# CITY OF ALBUQUERQUE

August 5, 2014

**Re: Smith's #485 Fuel Center  
Grading and Drainage Plan  
Engineer's Stamp Date 7-8-14 (F18-D057)**

1 **Northeast Driveway Detail**
Scale: 1" = 10'

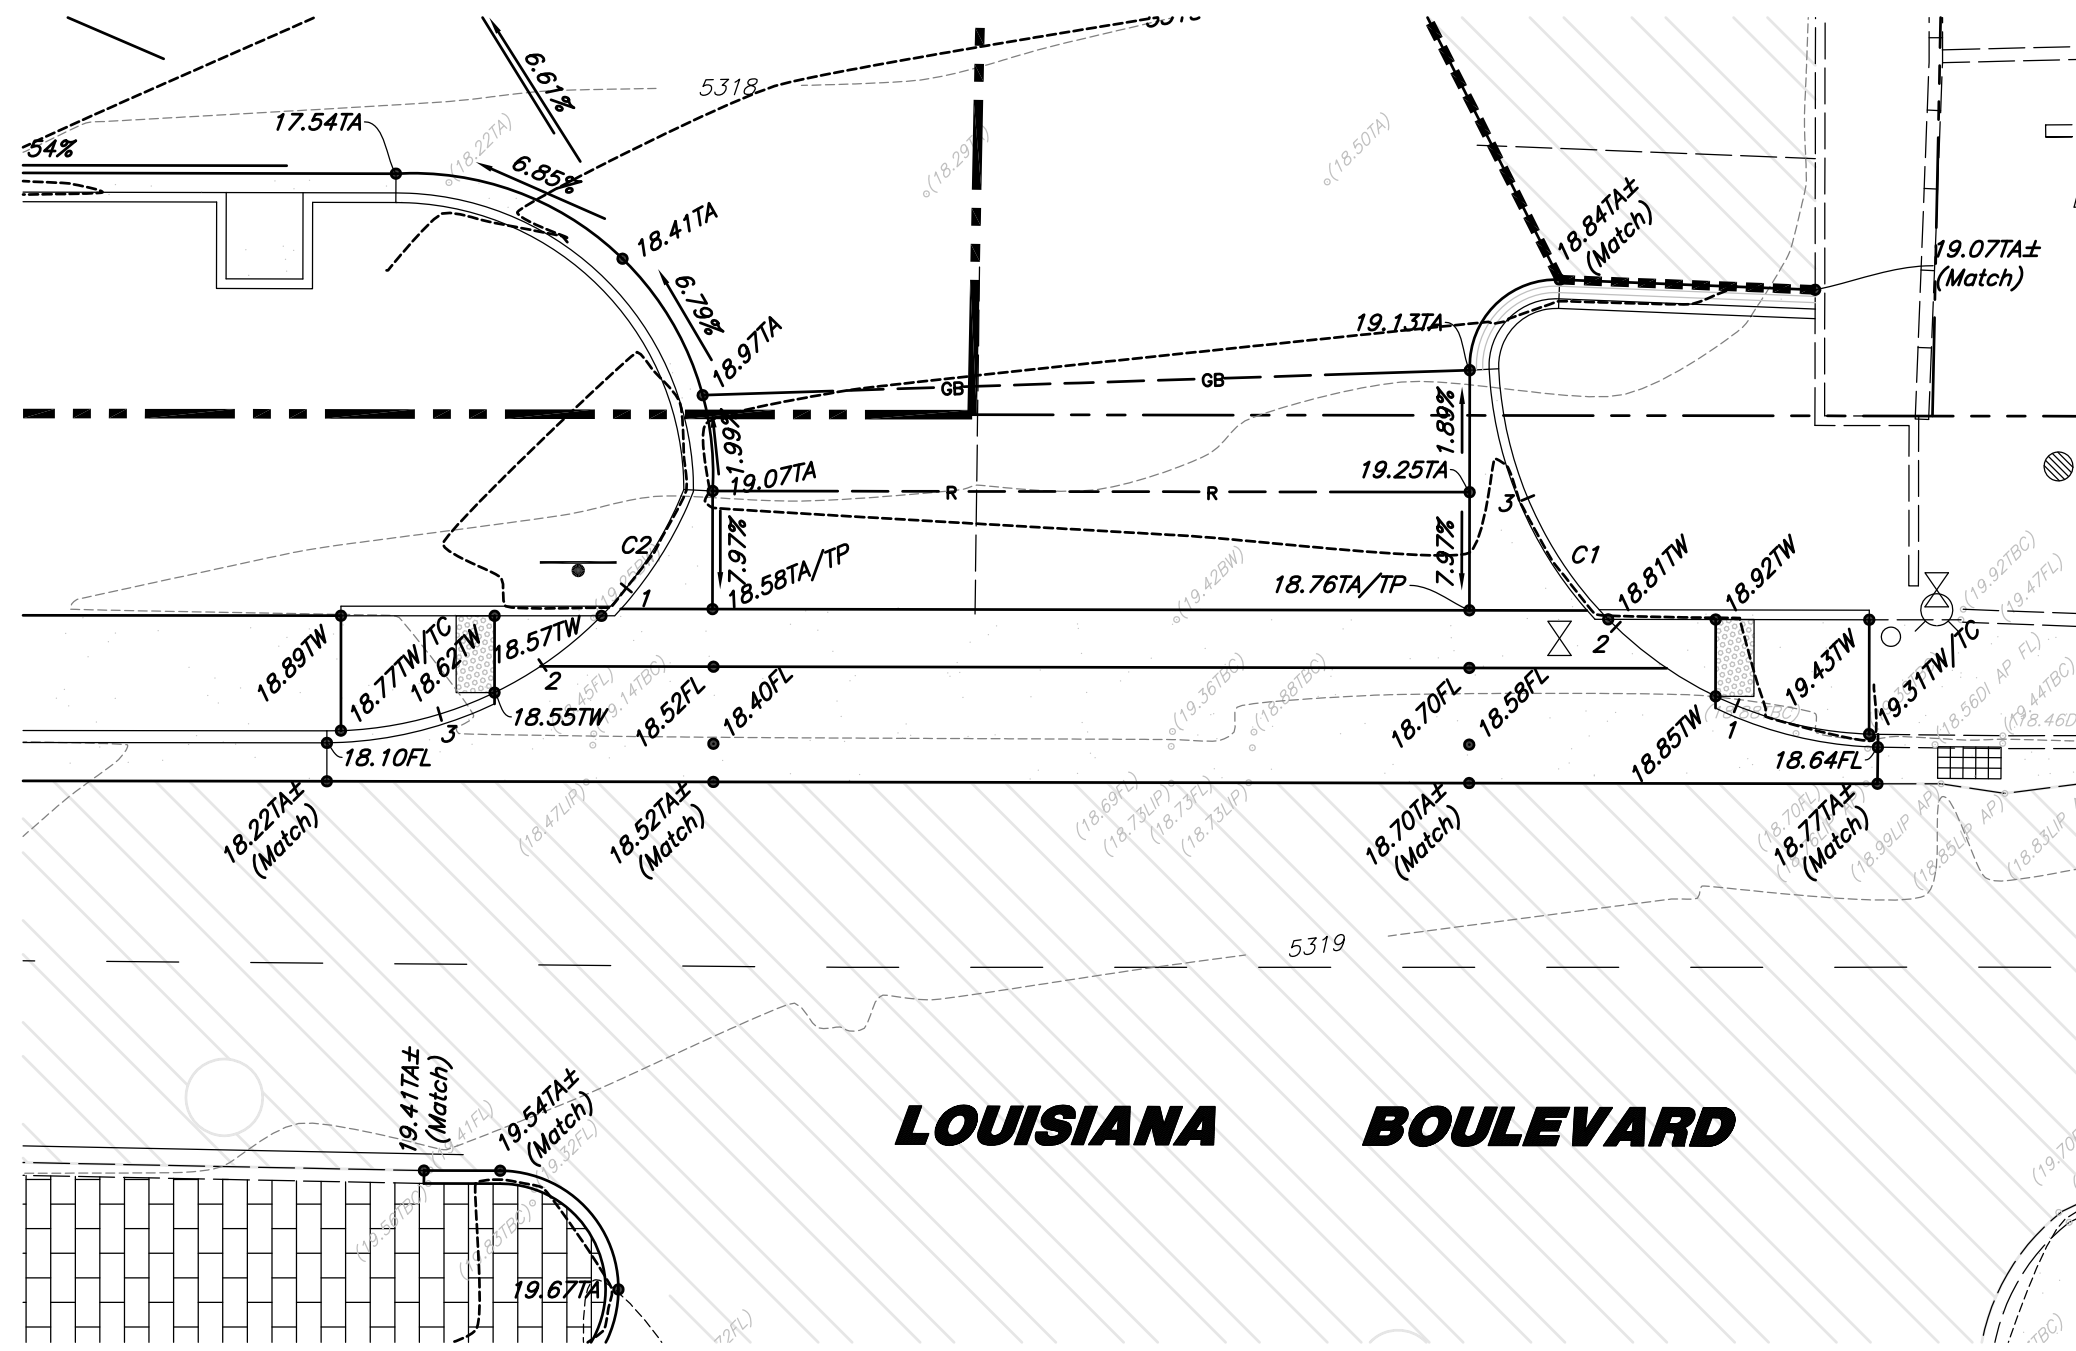
1. Provide the assumptions and calculations showing the storm drain and oil/water separator are adequately sized.
2. The entrance from Montgomery is at 8% on the west side and 11% on the east side of the entrance. Provide a smoother transition.
